Please upload the amended drainage plans attached to this email onto Ocella for **LU/90/20/DOC** for Parcels A2 and B6 at Hampton Park.

Comments;

Paul Cann
Principal Engineer (Drainage)

Hydro-Brake Control Chamber HB2

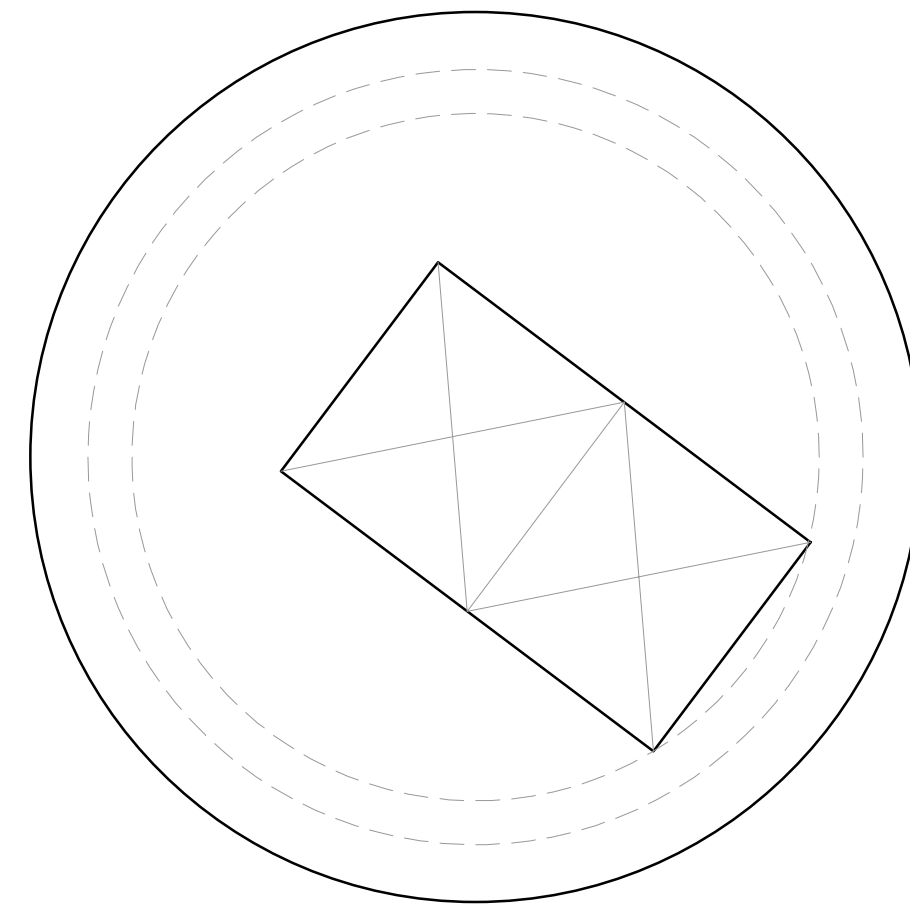
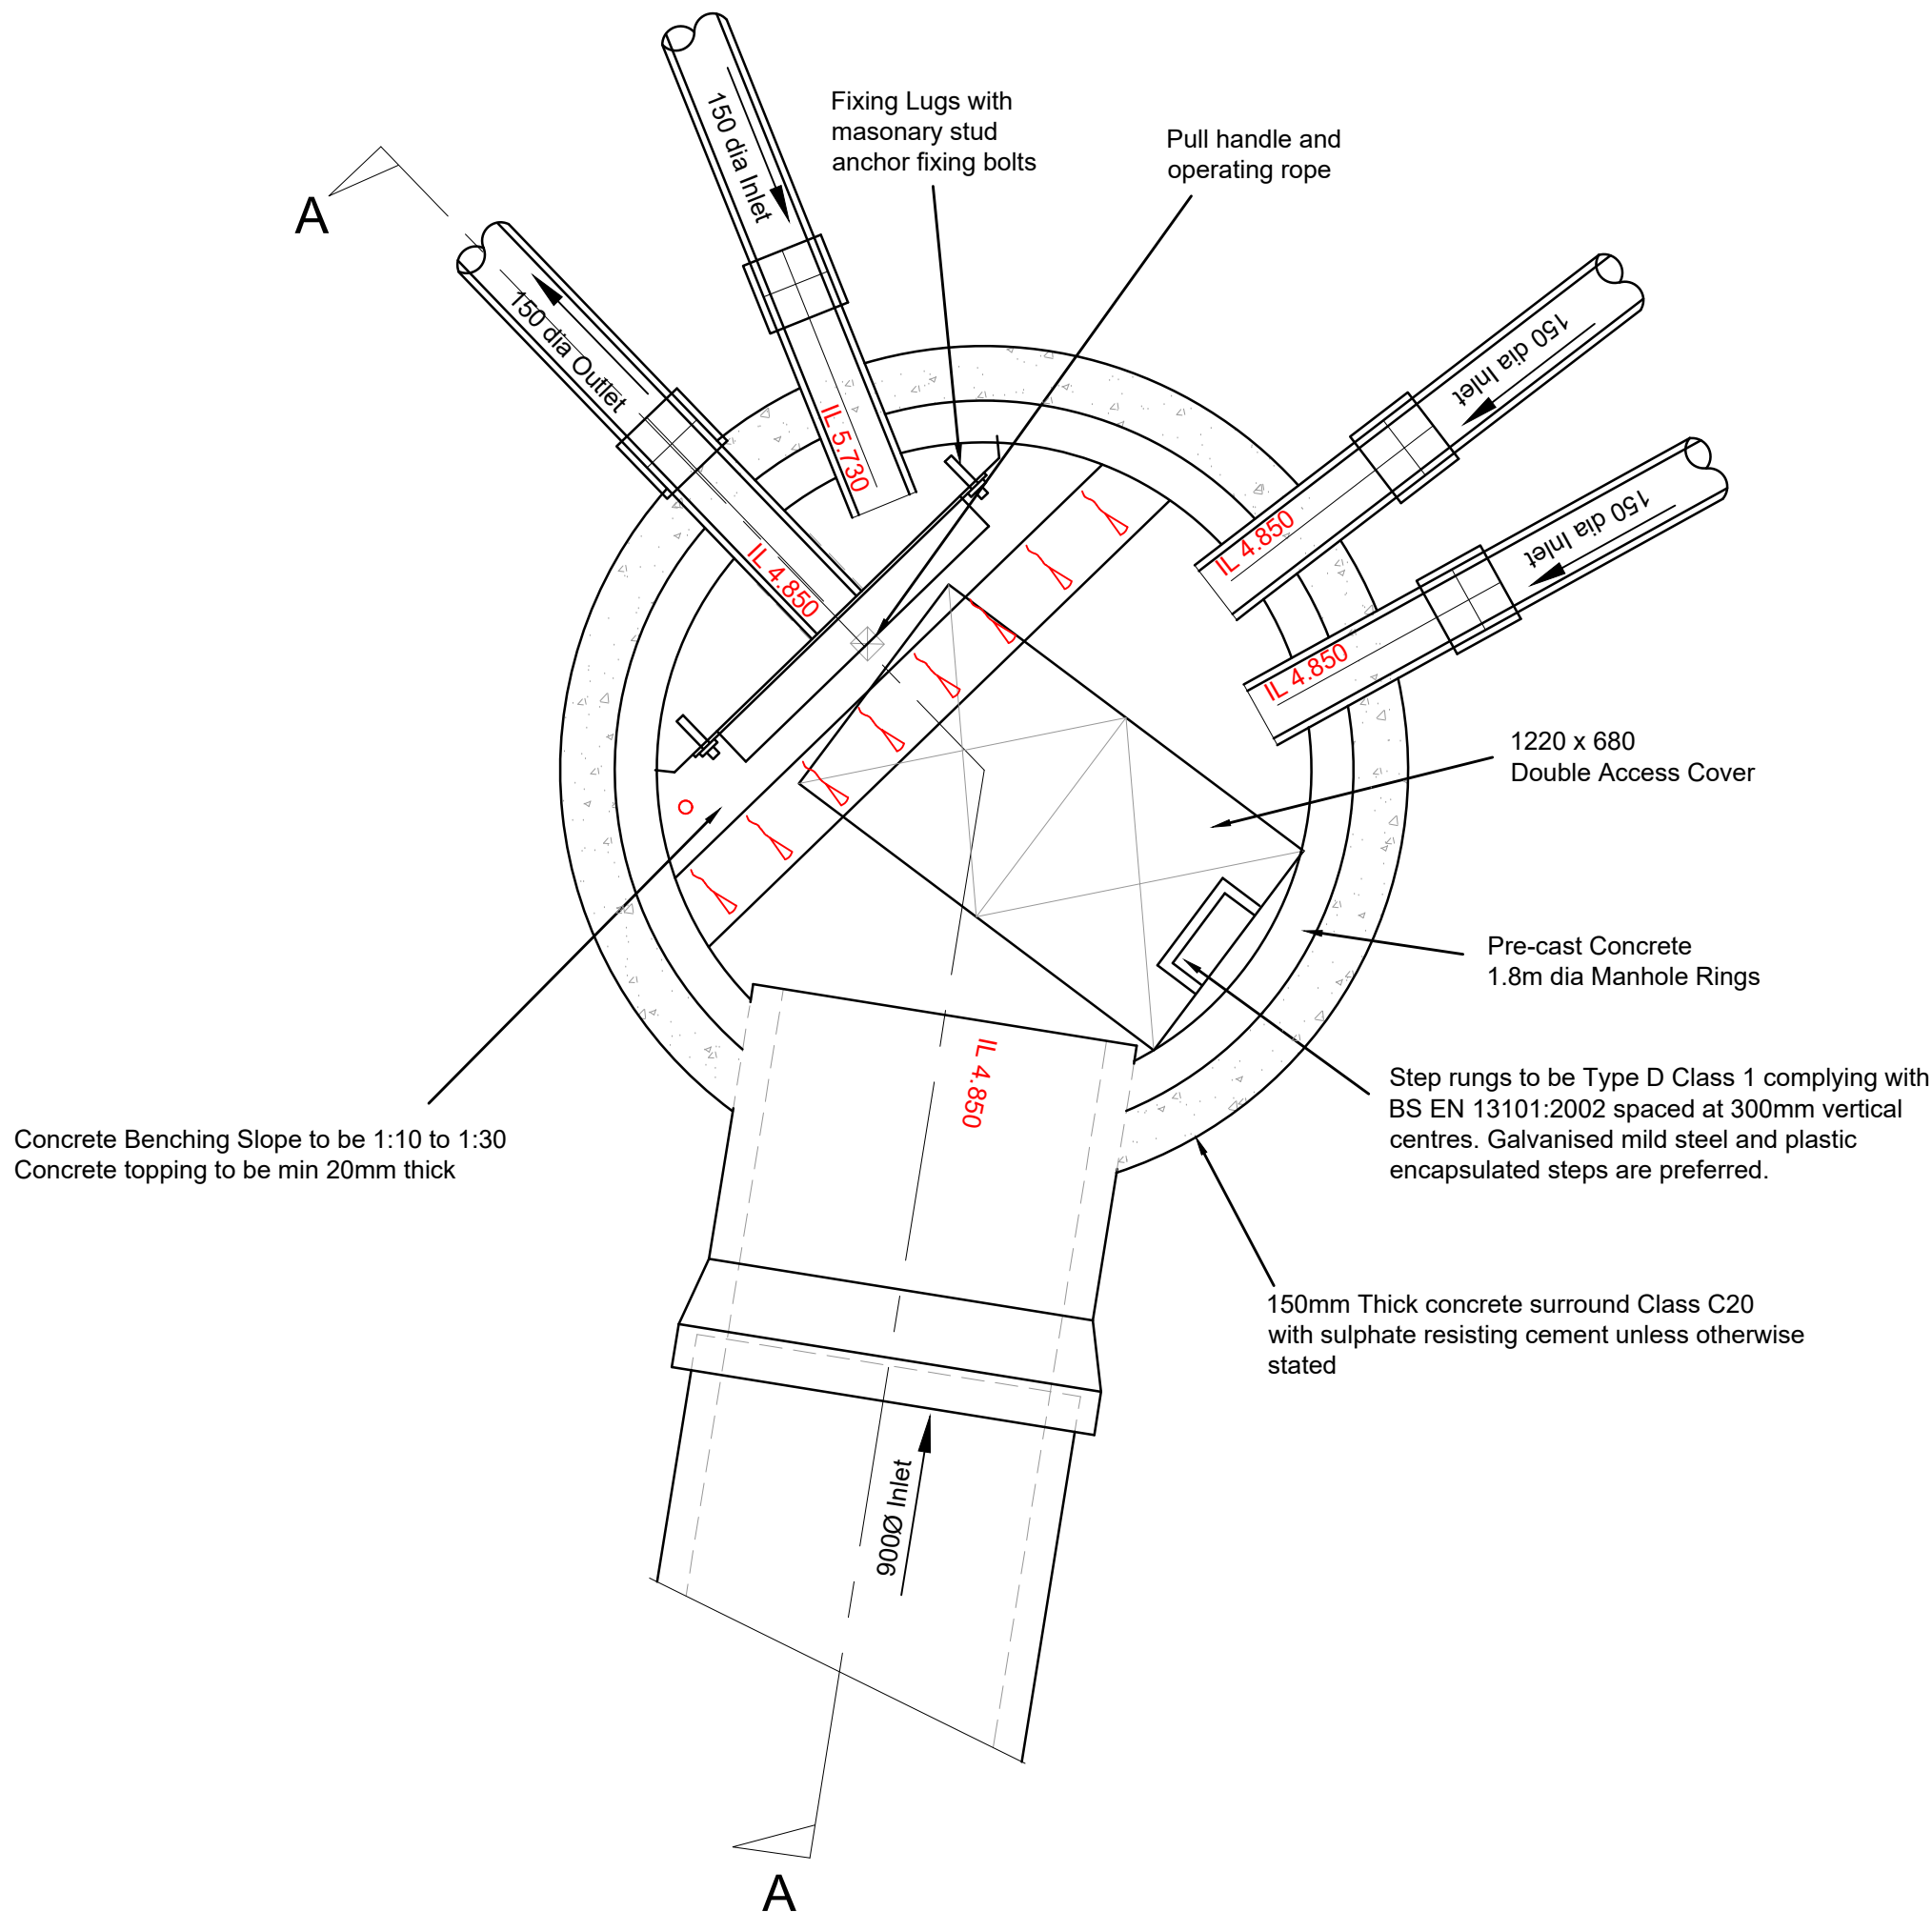
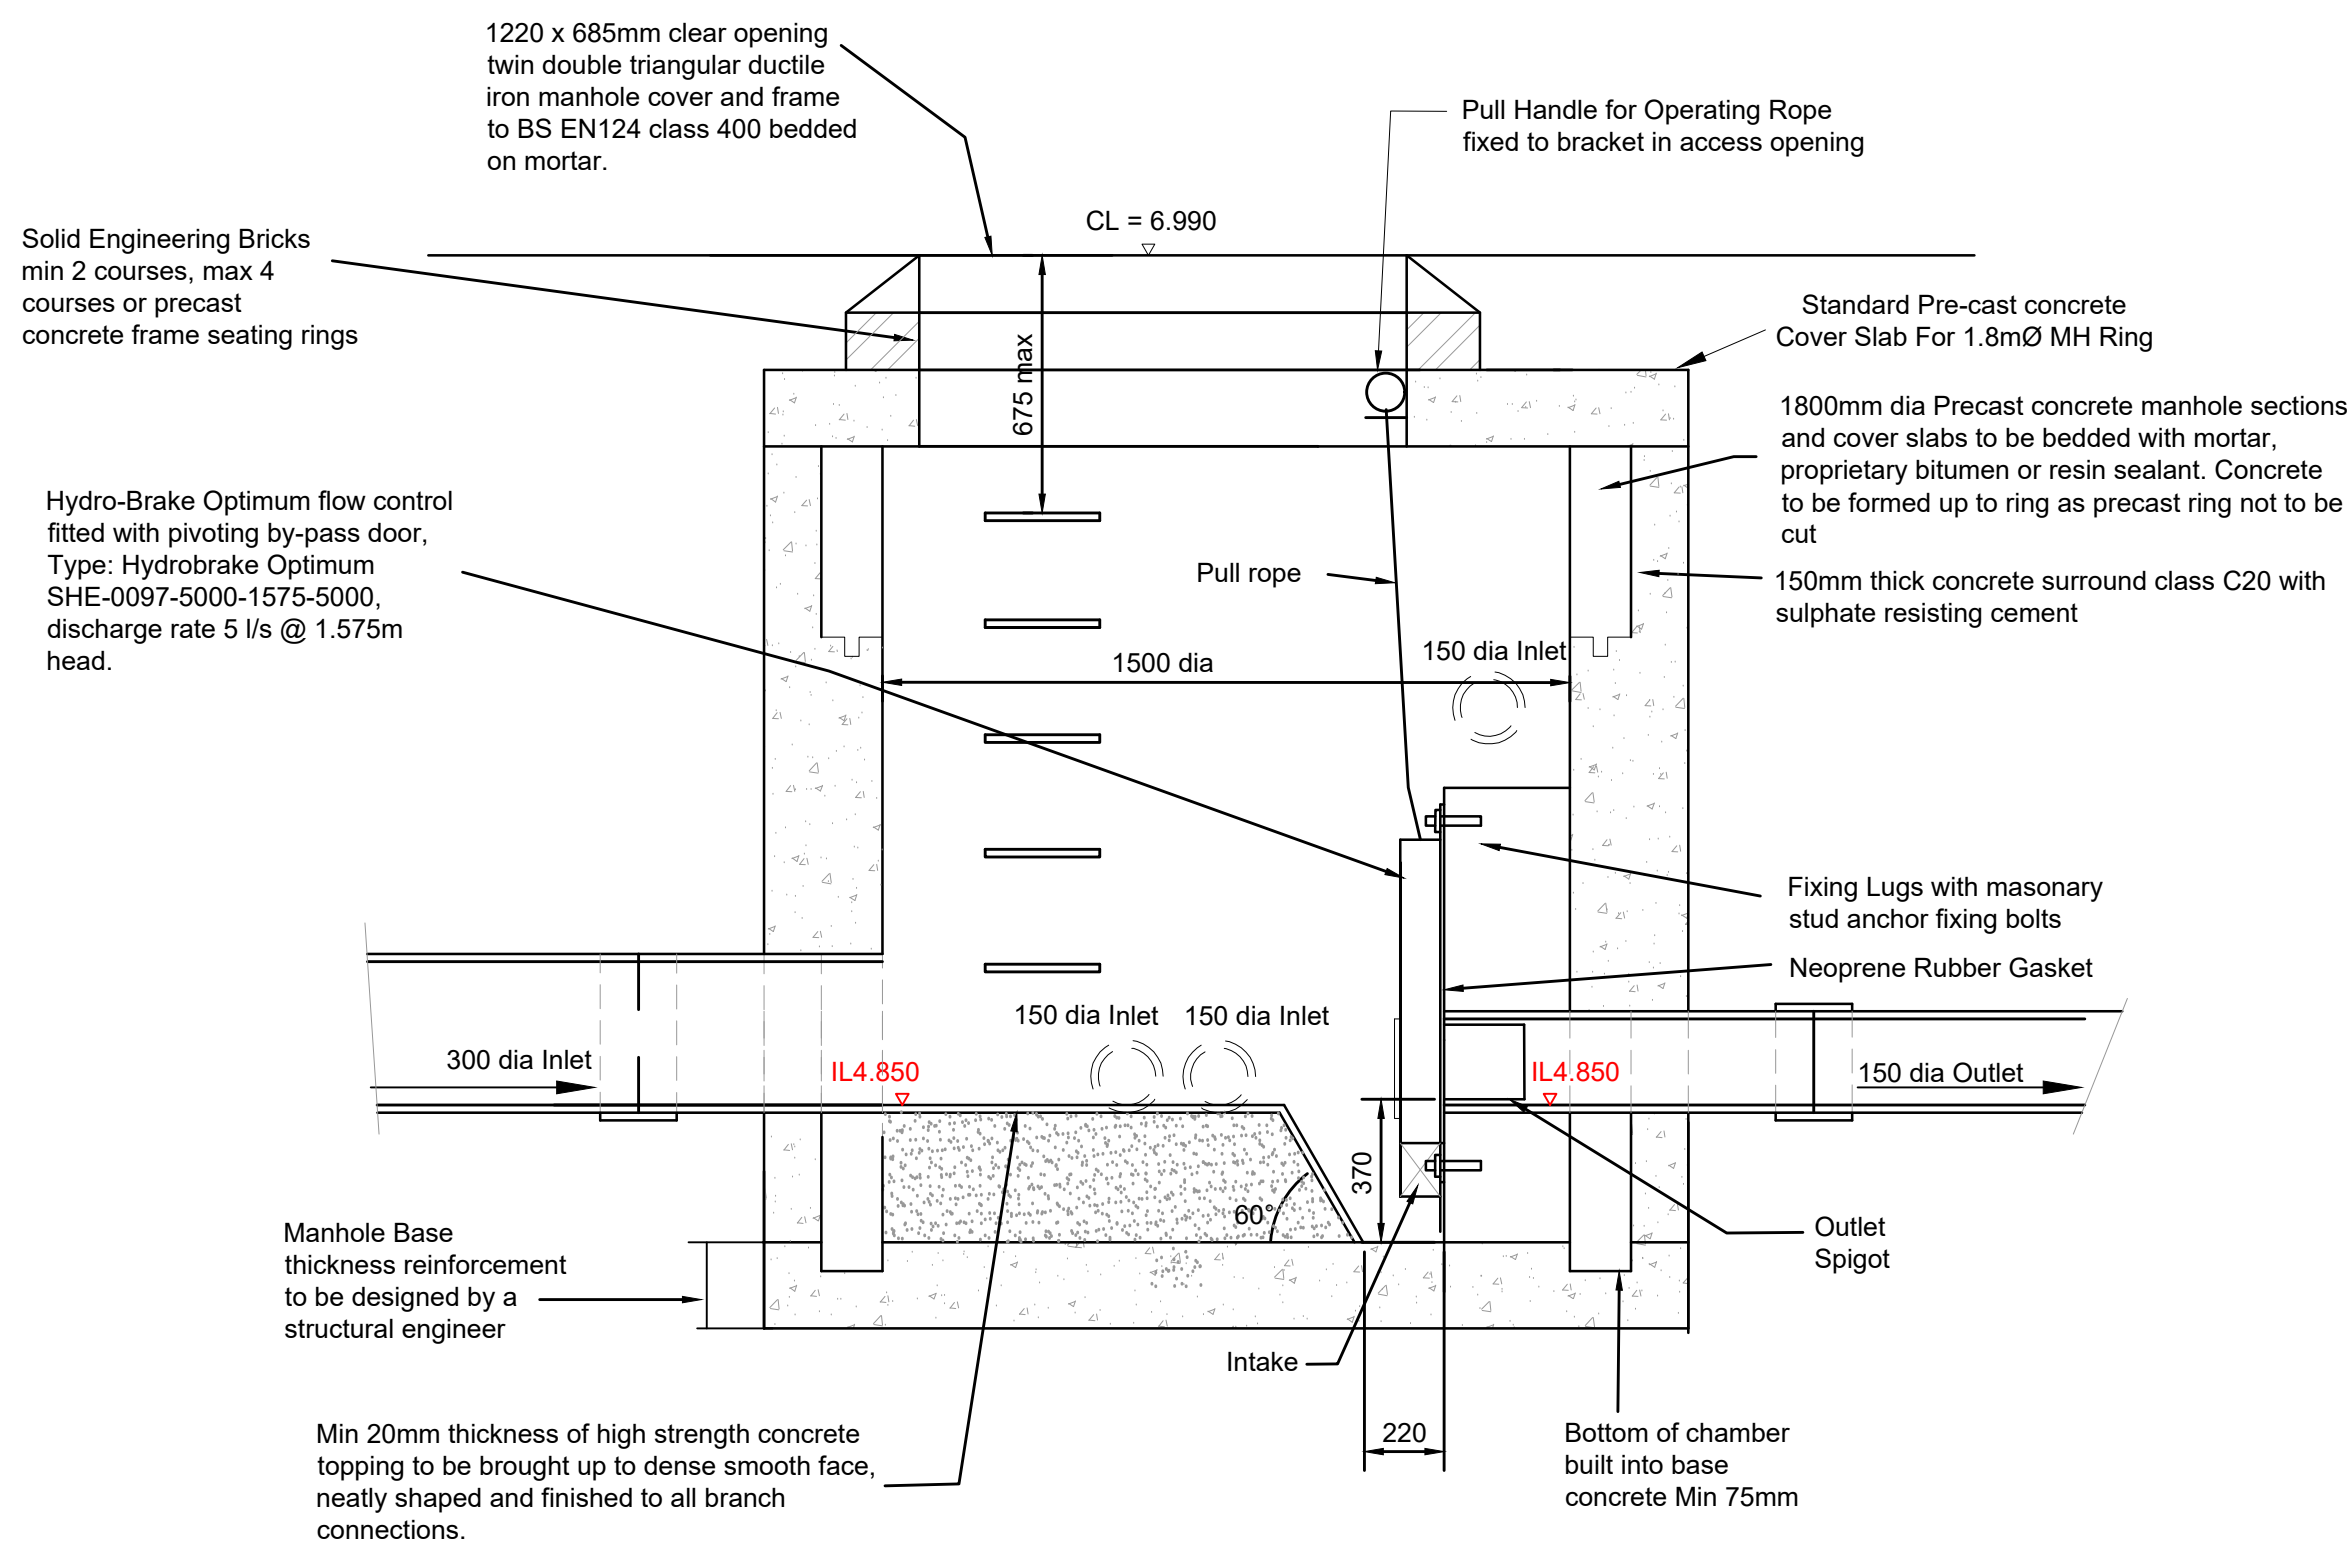
5. Hydrobrake chamber HB02 construction detail – plan view shows incoming 900mm pipe as opposed to 300mm and 1.8m dia rings as opposed to 1.5 dia. Incoming 150mm connections to connect soffit to soffit with 300mm pipe. The gully that is connecting against flow and above hydrobrake is not ideal but willing to accept it in this instance (Section A-A shows it in a different location to the plan view?)

6. Both hydrobrake chambers – show base thickness/reinforcement details.
7. Existing manhole SW03A – just upstream of SWA2_01 – what is its purpose? Invert level is lower than the downstream manhole. Please clarify if it is required and adjust as necessary.
